DOC17/599447-01
SSD 8647

SSD 8647 – HORNSBY HOSPITAL RE-DEVELOPMENT – ENVIRONMENTAL IMPACT STATEMENT (EIS)

- ENVIRONMENT PROTECTION AUTHORITY COMMENTS – HORNSBY HOSPITAL RE-DEVELOPMENT STAGE 2 EIS

APPENDIX 2 – NOISE MONITORING ALONG DERBY STREET

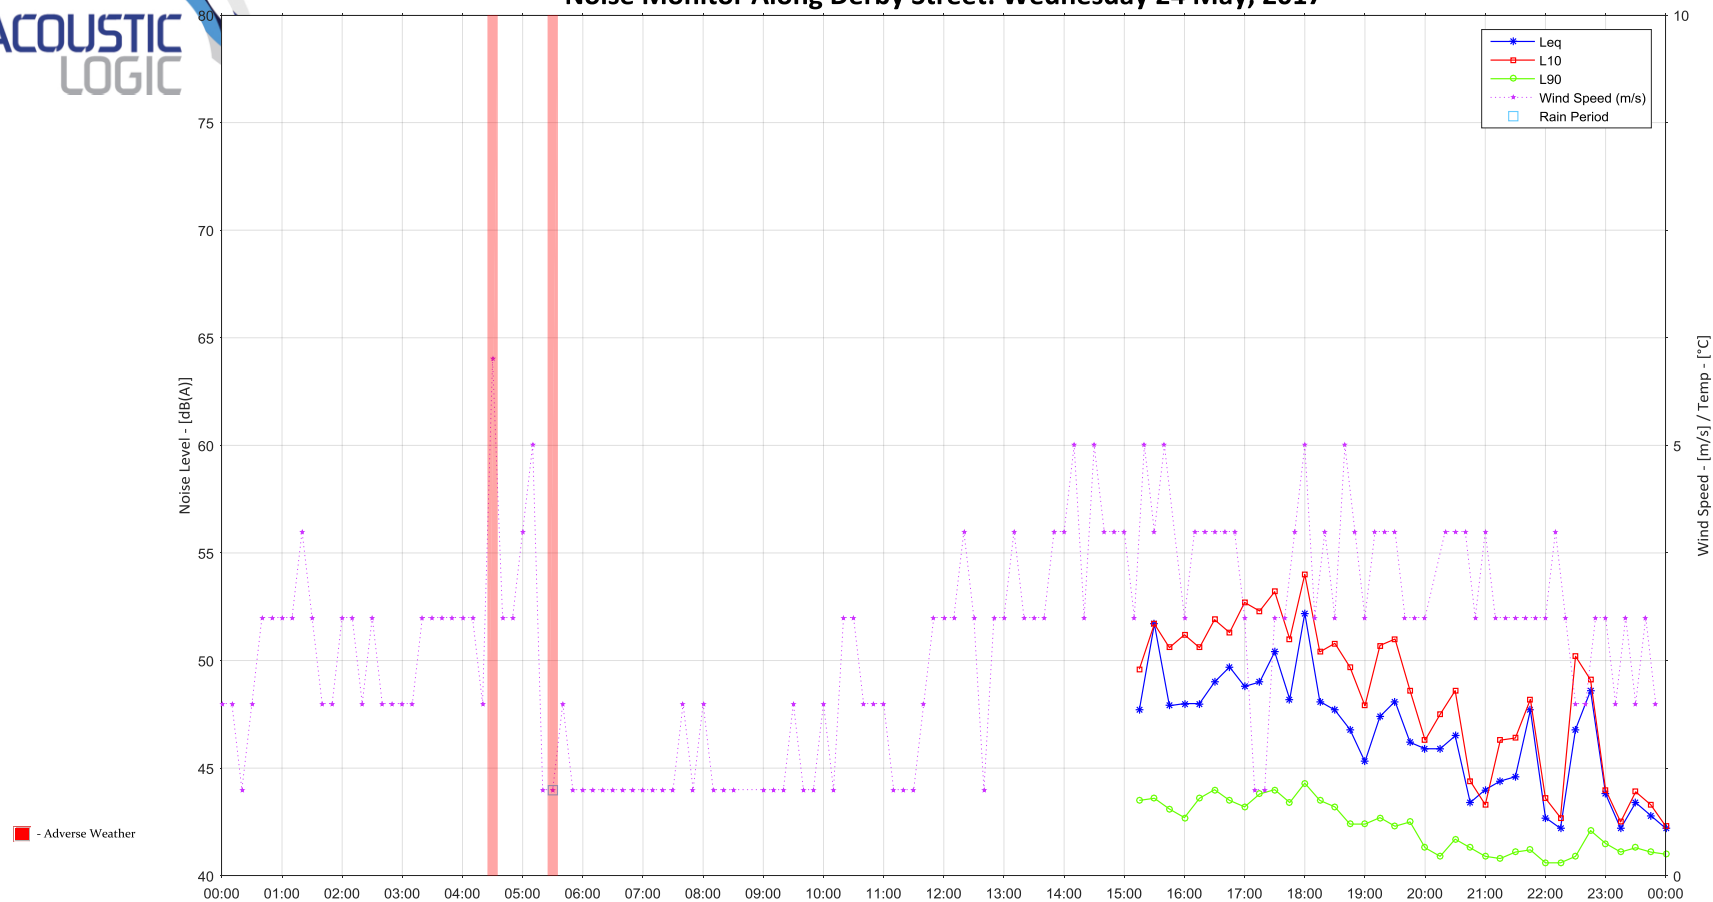
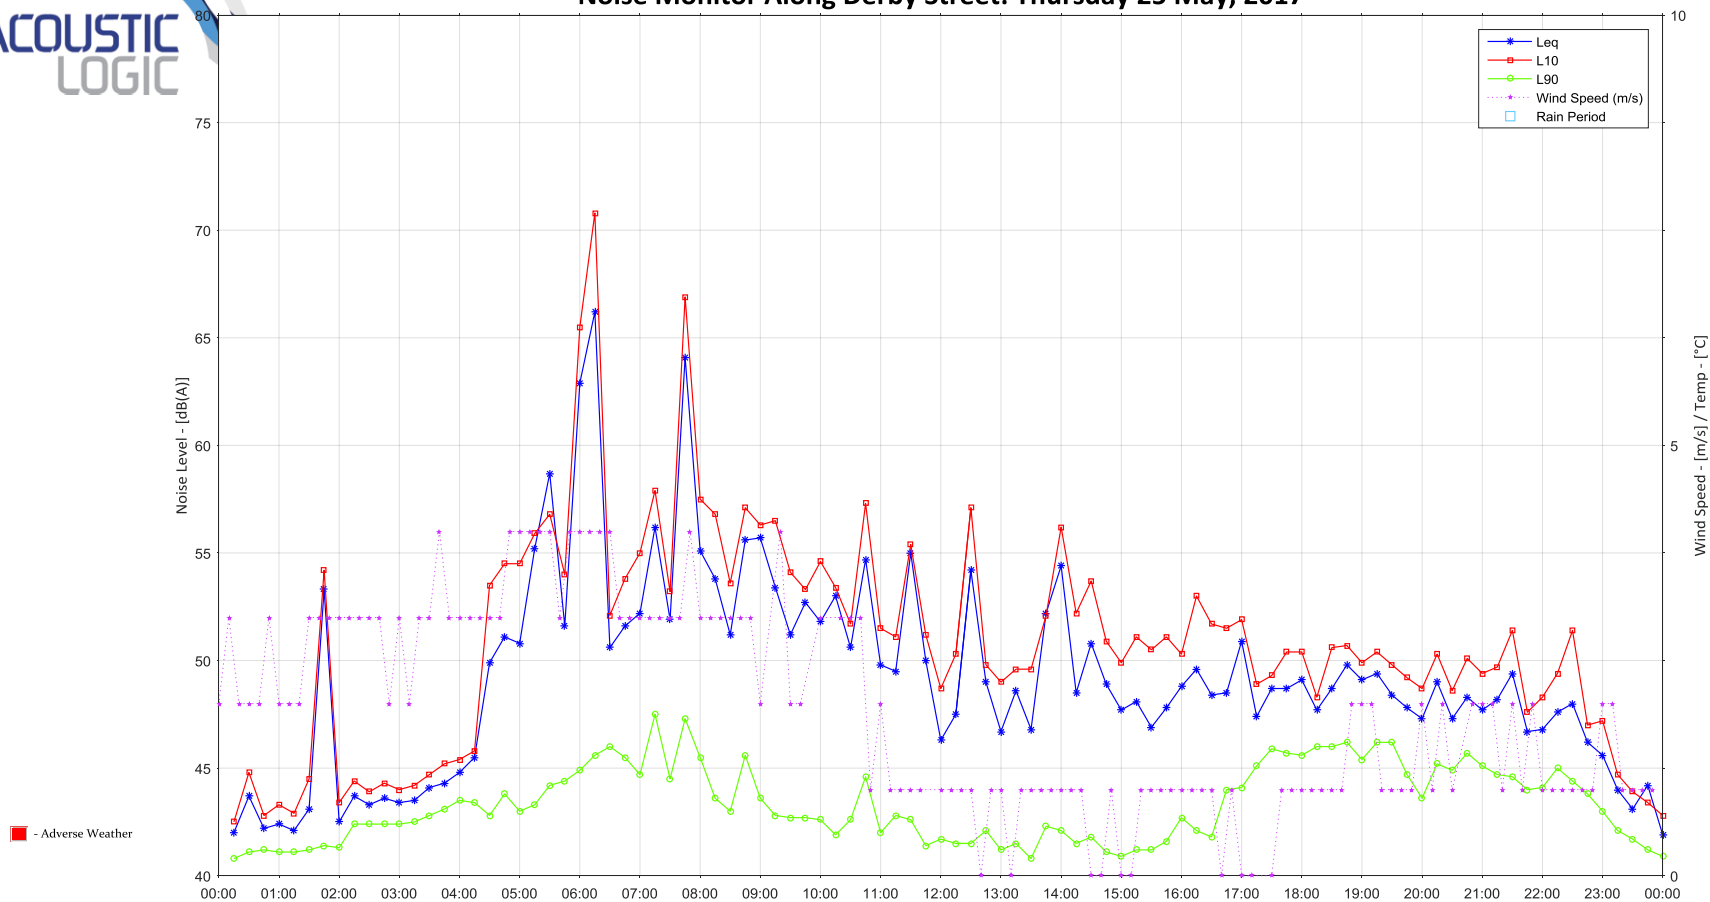
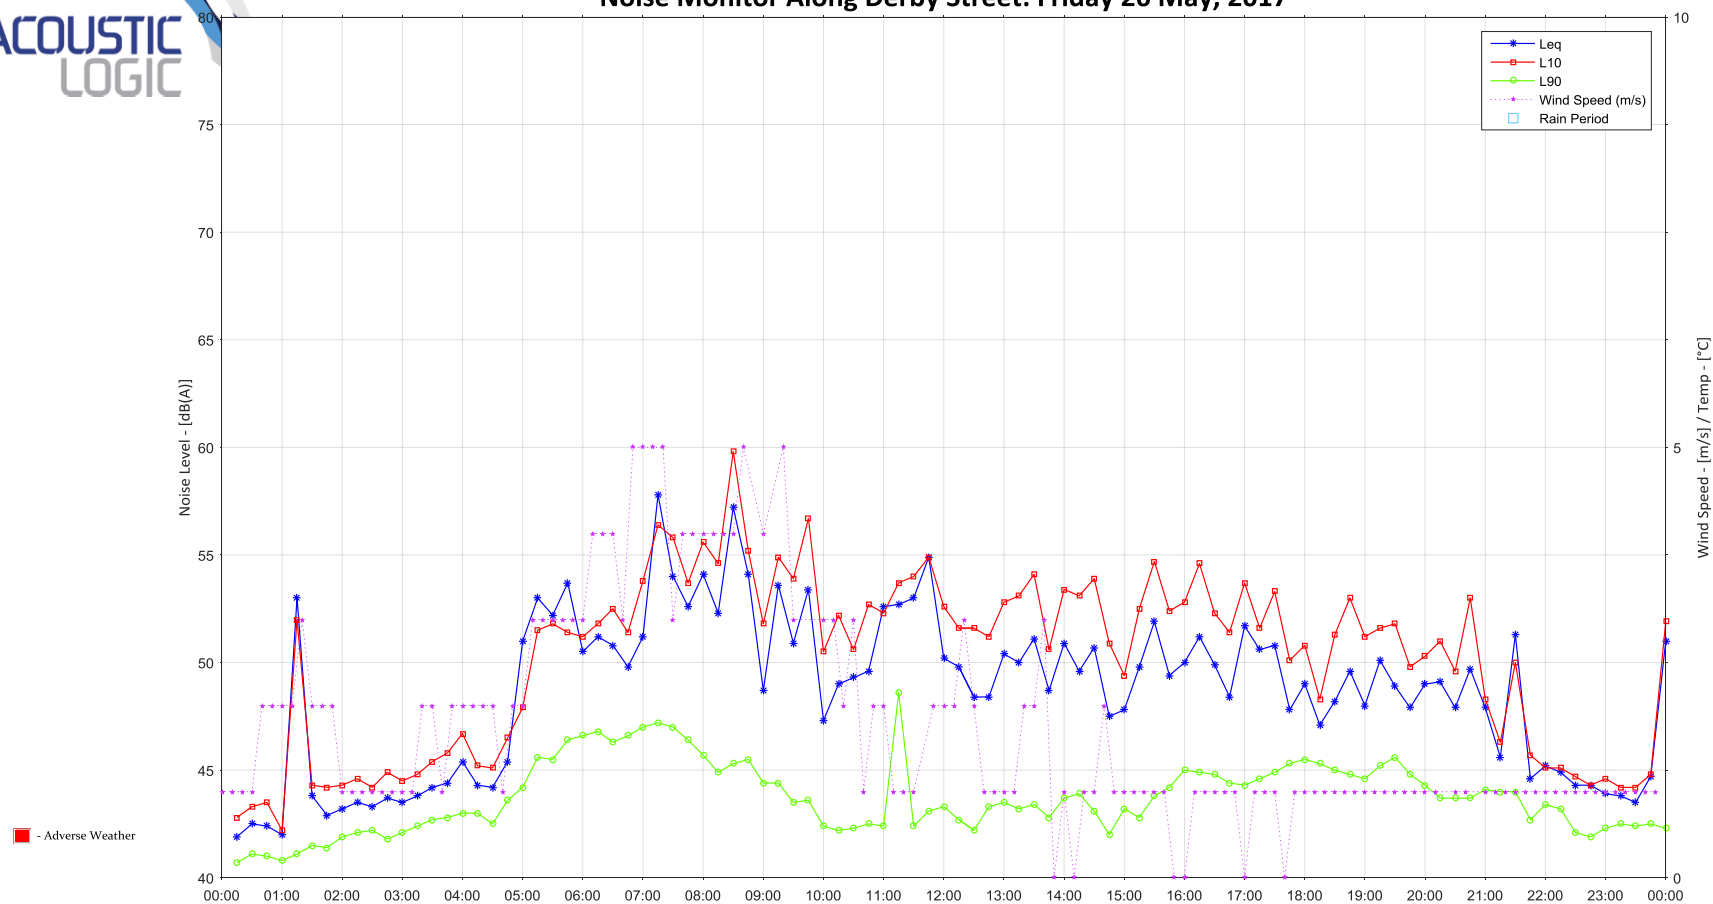
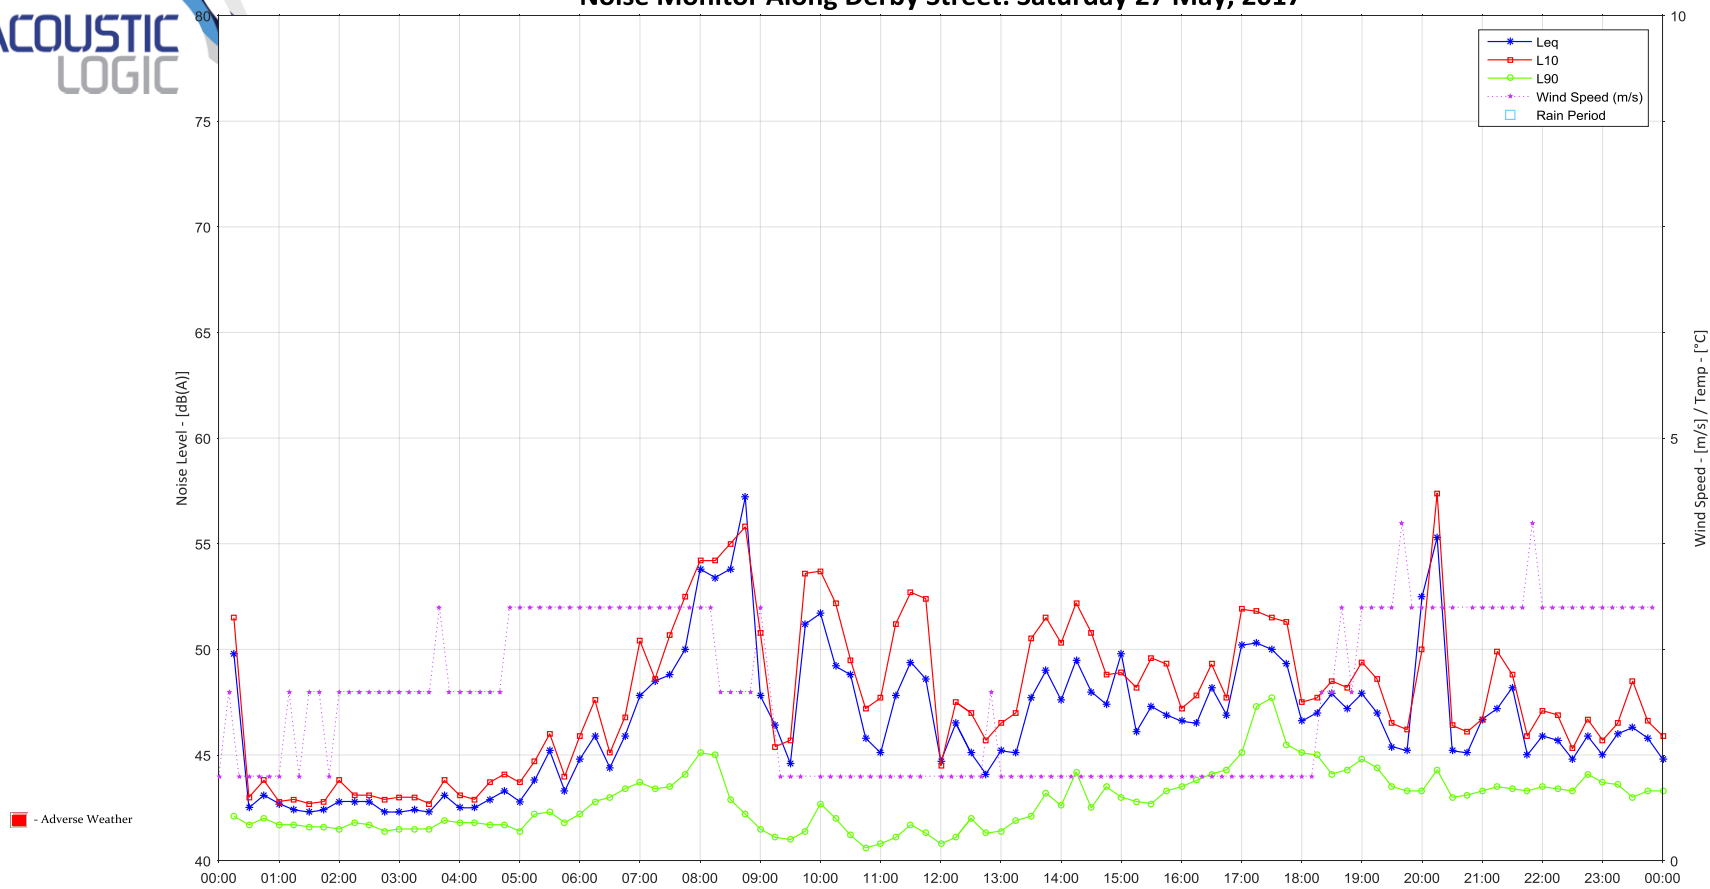
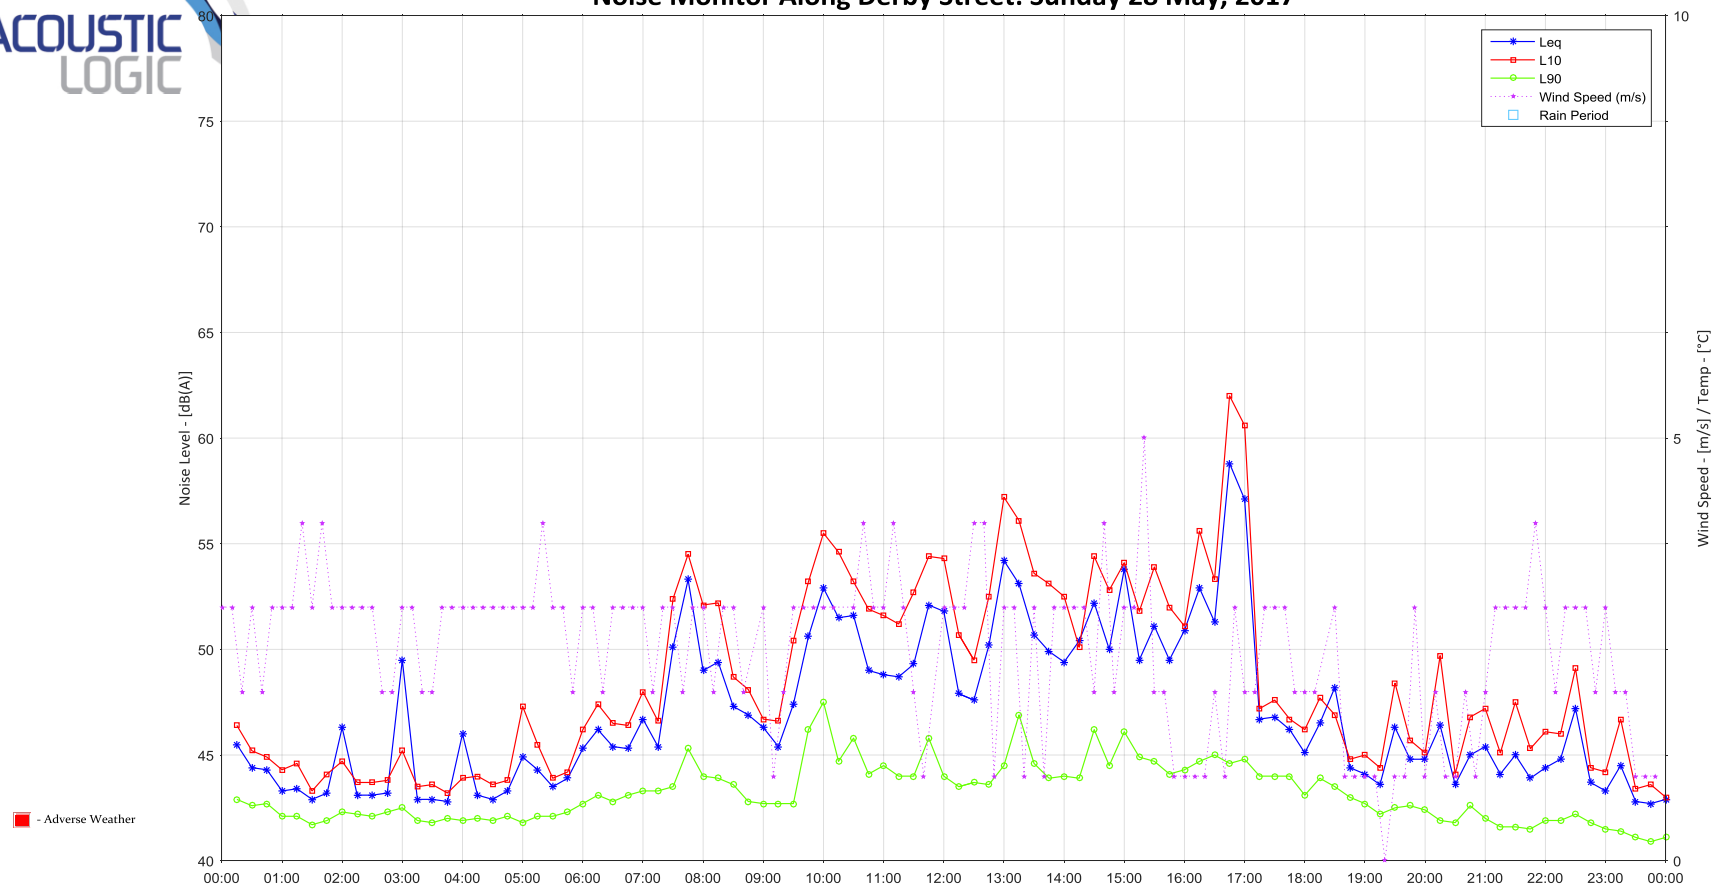
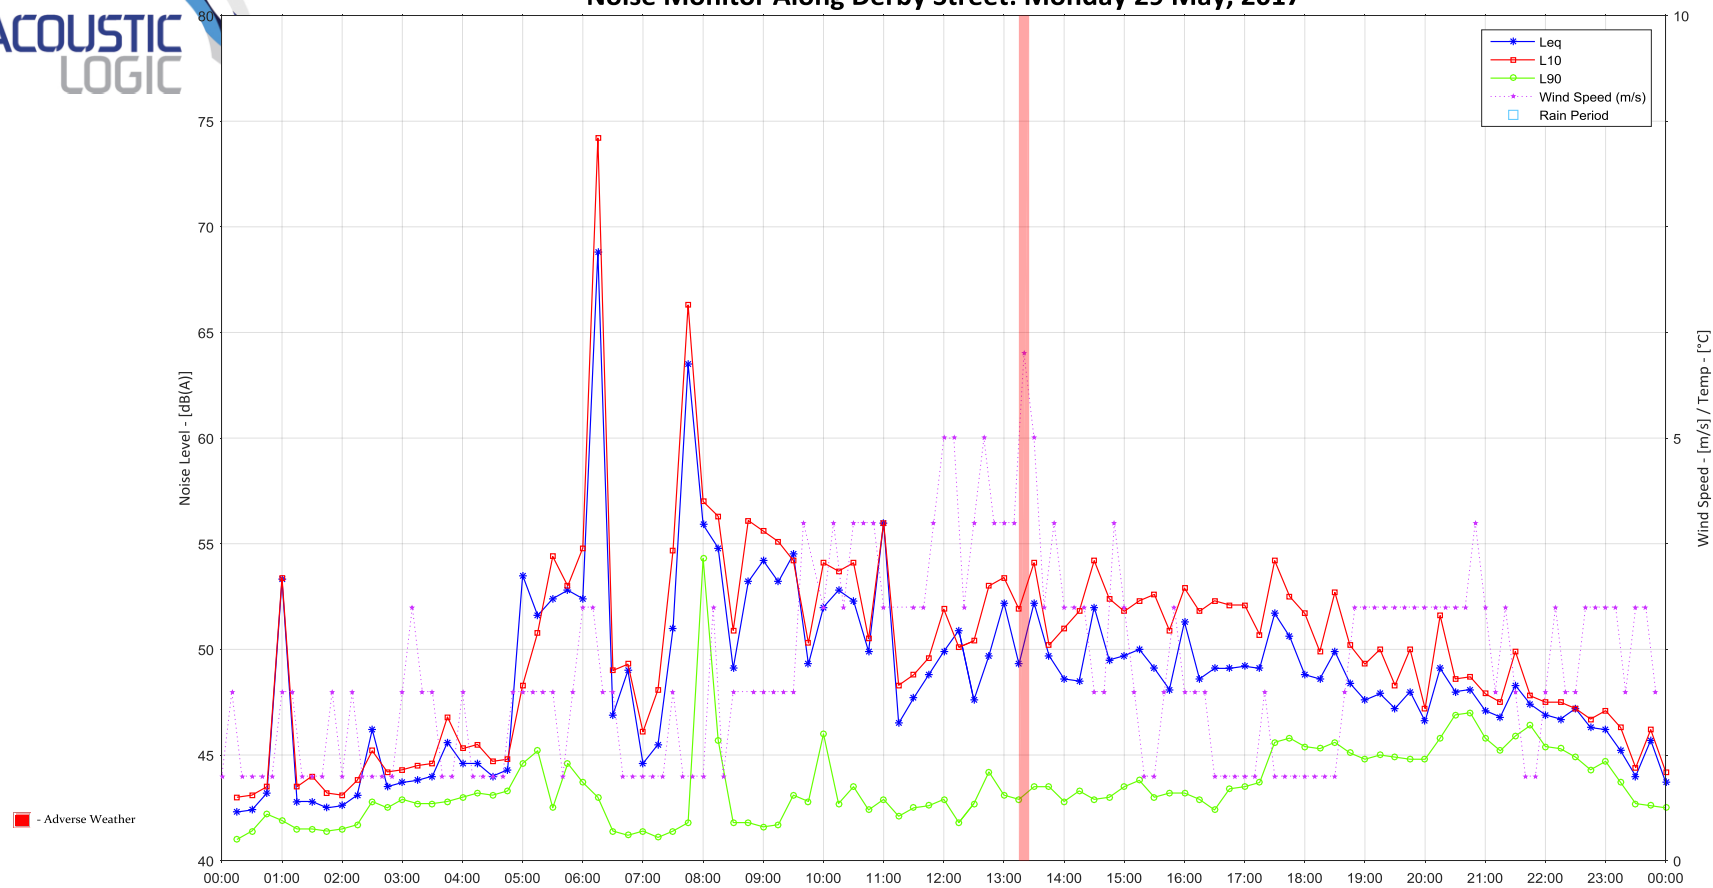
The EPA is concerned that the noise monitoring graphs presented in 'Appendix 2 - Noise Monitoring Along **Derby Street**' to EIS Appendix Q appear instead to be a duplicate of graphs for Burnett Street and thus that the data for Derby Street appears to have been omitted from the EIS.

- (a) the legends to some monitoring graphs appear to be misaligned (e.g. wind speed, rain period),

- (b) the legends to monitoring graphs includes a blue marker for 'rain period' and although rain was observed on several days during the various monitoring periods (i.e. 24 May to 7 June 2017), no rain periods are represented in the graphs, and
- (c) some of the monitoring graphs include sections of red highlight, but there is no red marker in the legend to those graphs to identify the meaning of those red highlighted periods, and
- (d) Appendix Q does not appear to identify when noise monitoring loggers were last laboratory calibrated which brings into question reliability of the recorded data.

- (a) the equivalent of a week's worth of valid data, measured at the potentially most affected noise sensitive receiver locations in Burdett Street, Derby Street and Palmertson Road; and
- (b) the results of attended monitoring, graphical results of unattended monitoring with a complete and accurate legend together with a table of assessment background and daily ambient levels.
